DEVIATION REQUEST AND DECISION FORM

Project Name :	The Gardens at North Carefree
Schedule No.(s) :	5500000135
Legal Description :	See attached

A deviation from the standards of or in Section **Chapter 2, Section 2.2.4 B** of the Engineering Criteria Manual (ECM) is requested.

ECM Standard Drawing SD_2-3: Urban Non-Residential Collector Roadway.

SHEET 14 OF 34

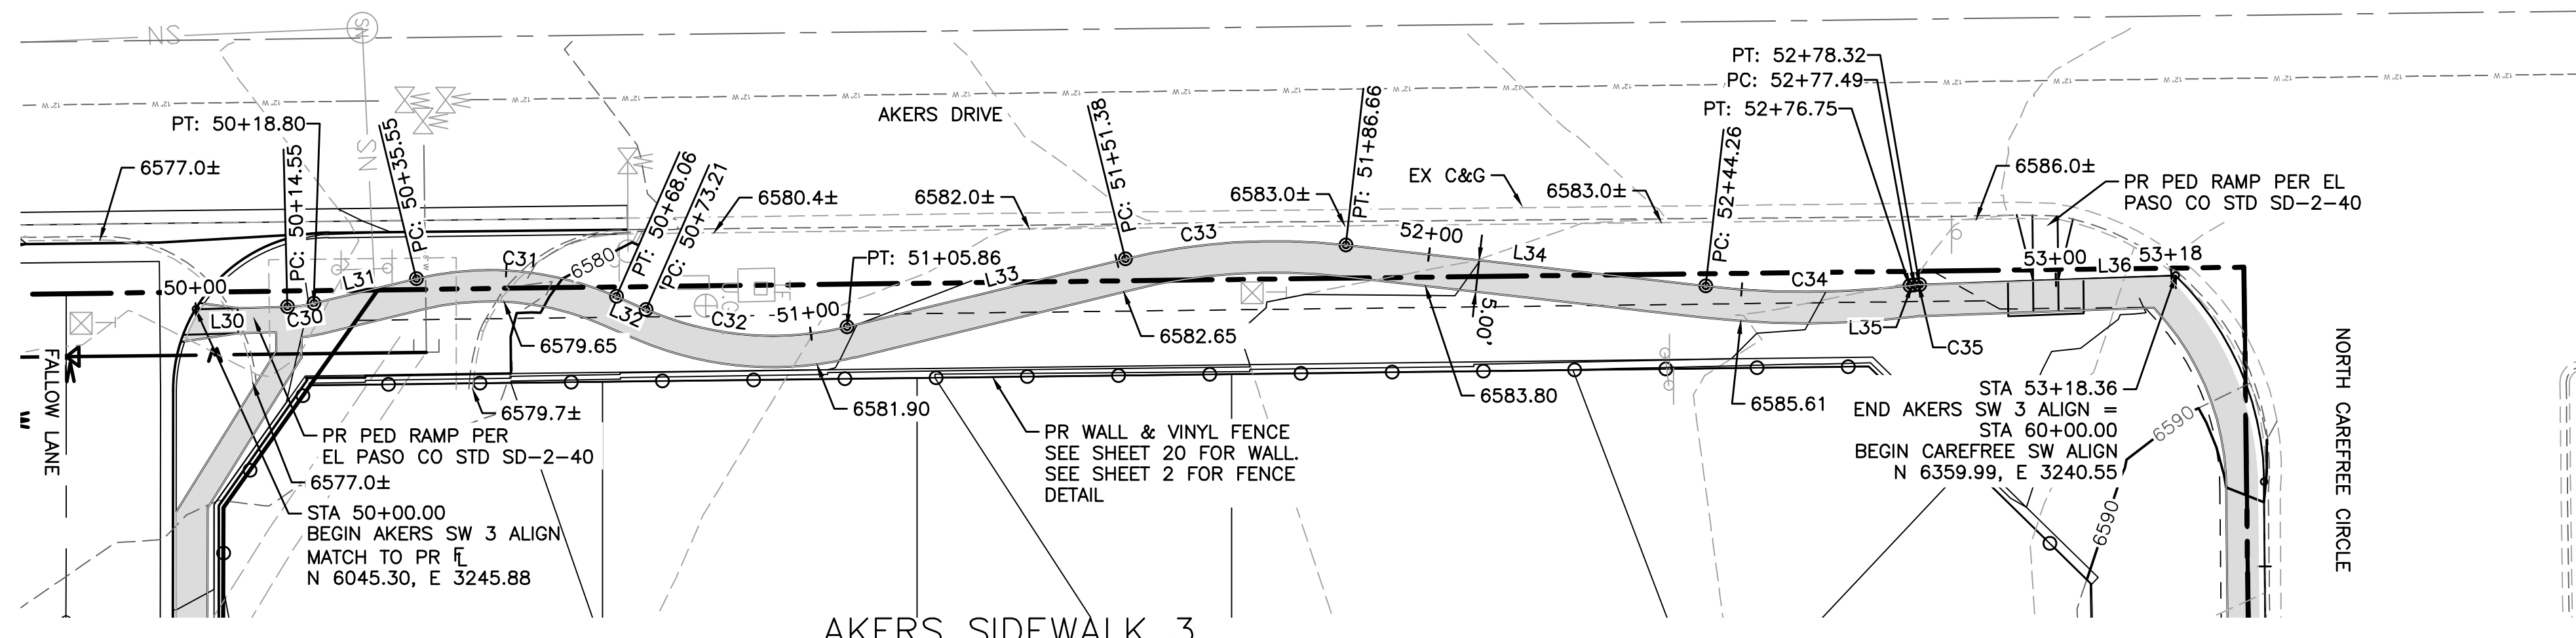
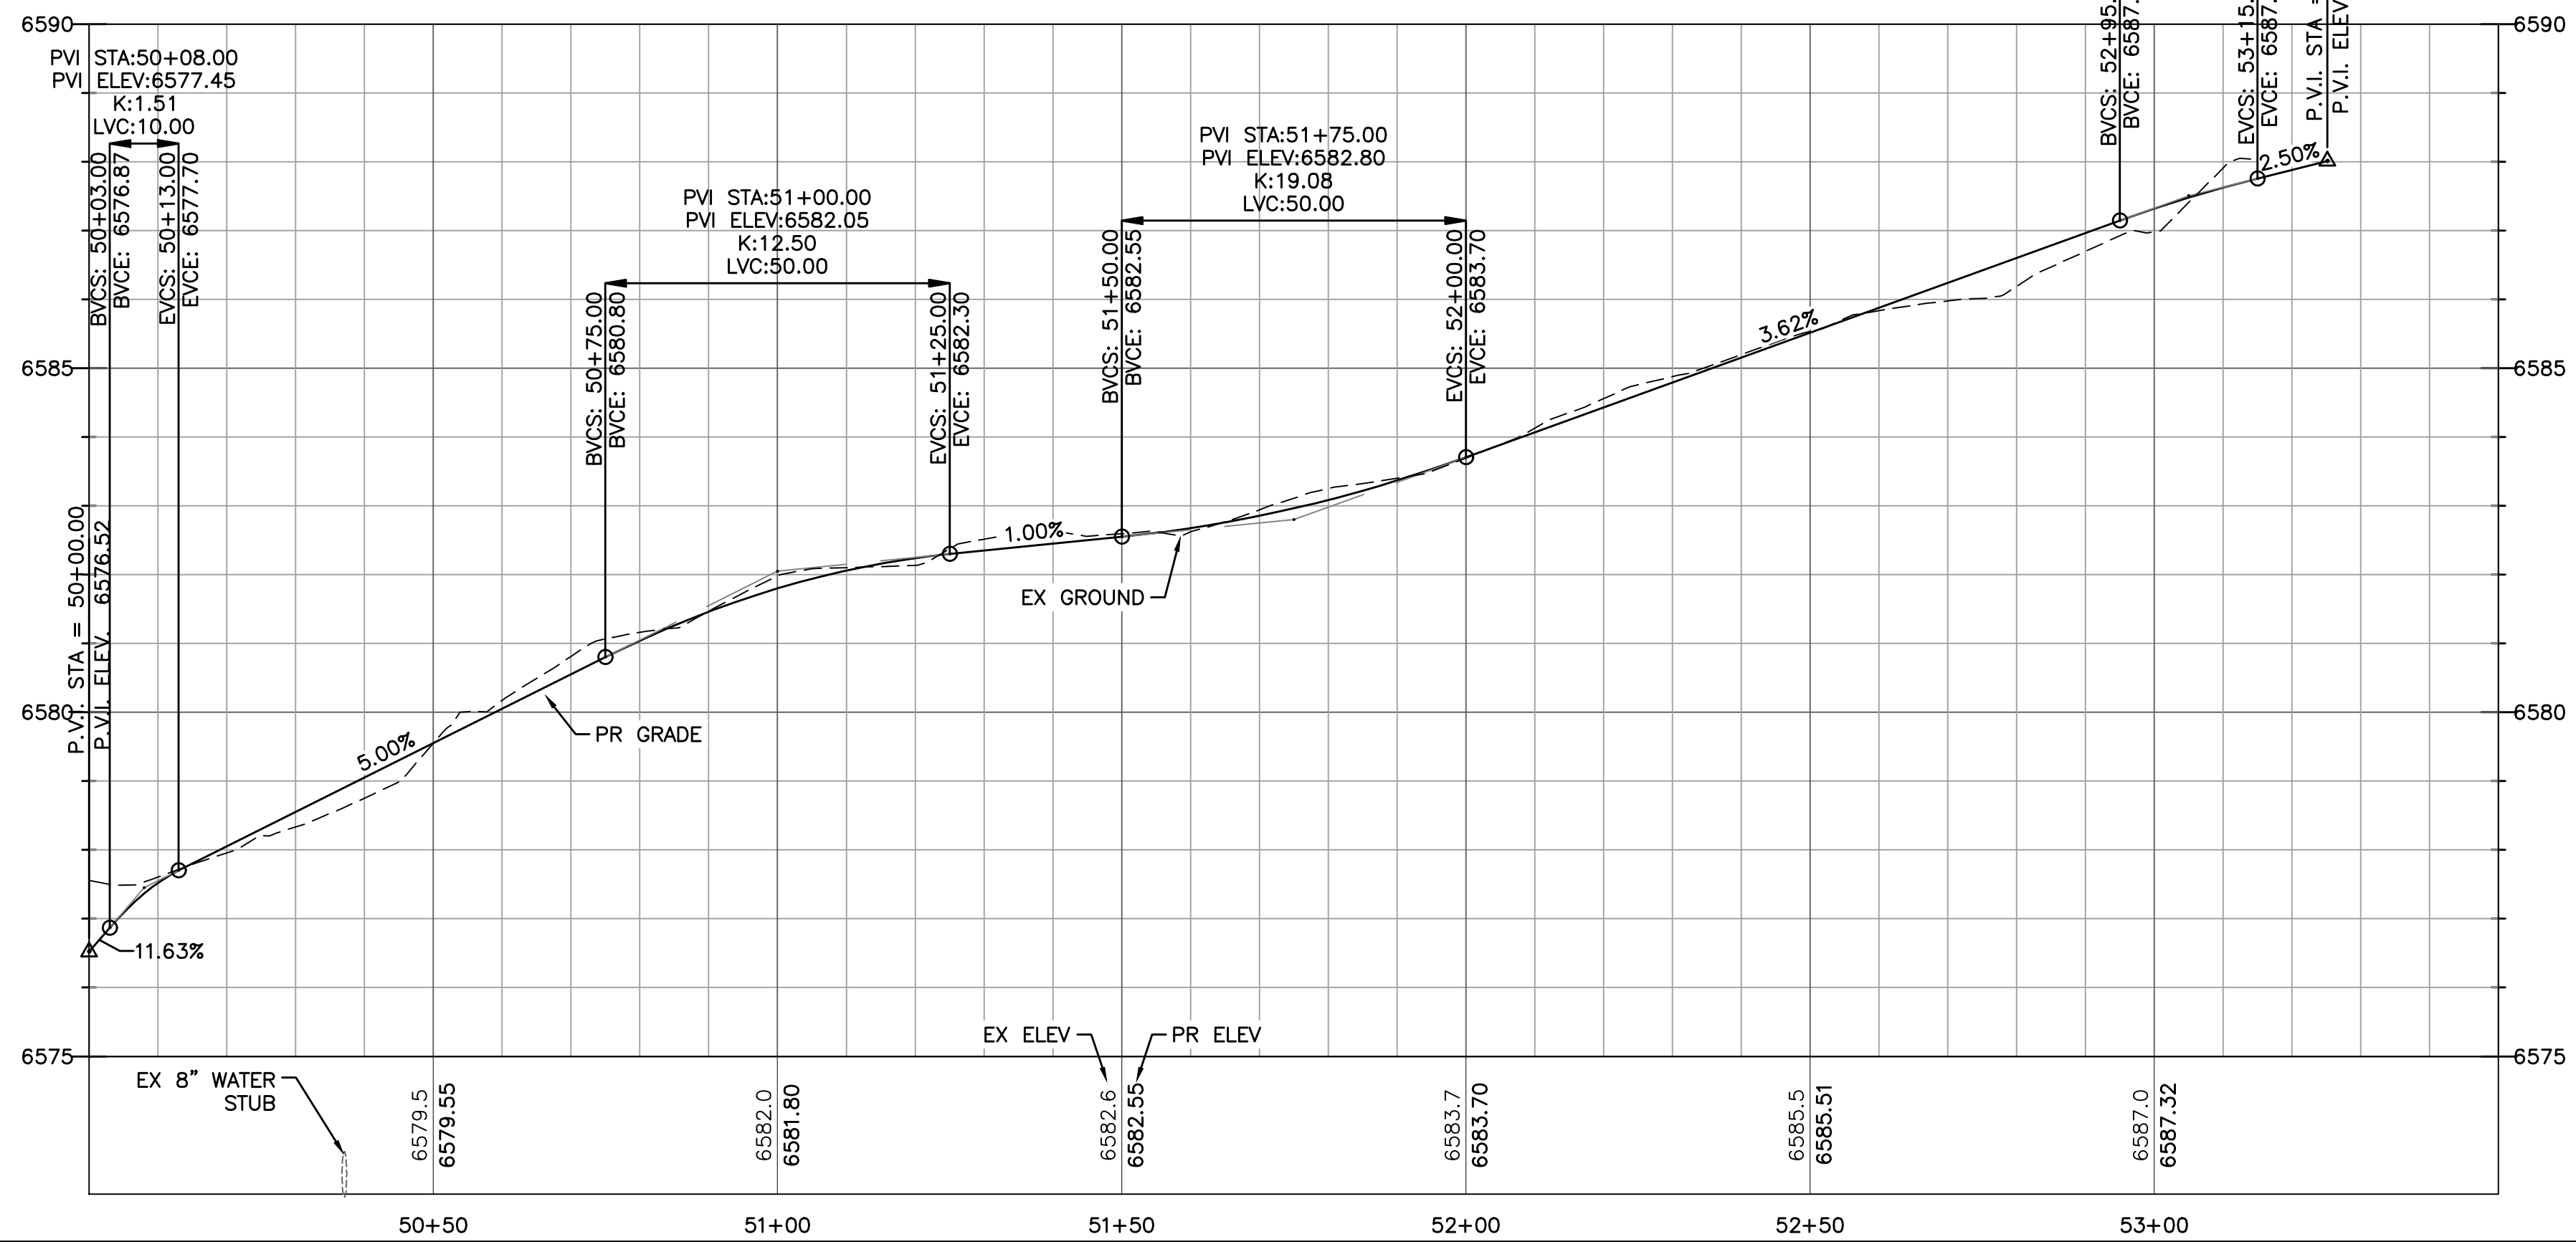
please provide an exhibit of the meandering sidewalk

There are portions of this sidewalk that are next to the curb and do not have this additional safe area behind the curb. Please update your justification accordingly.
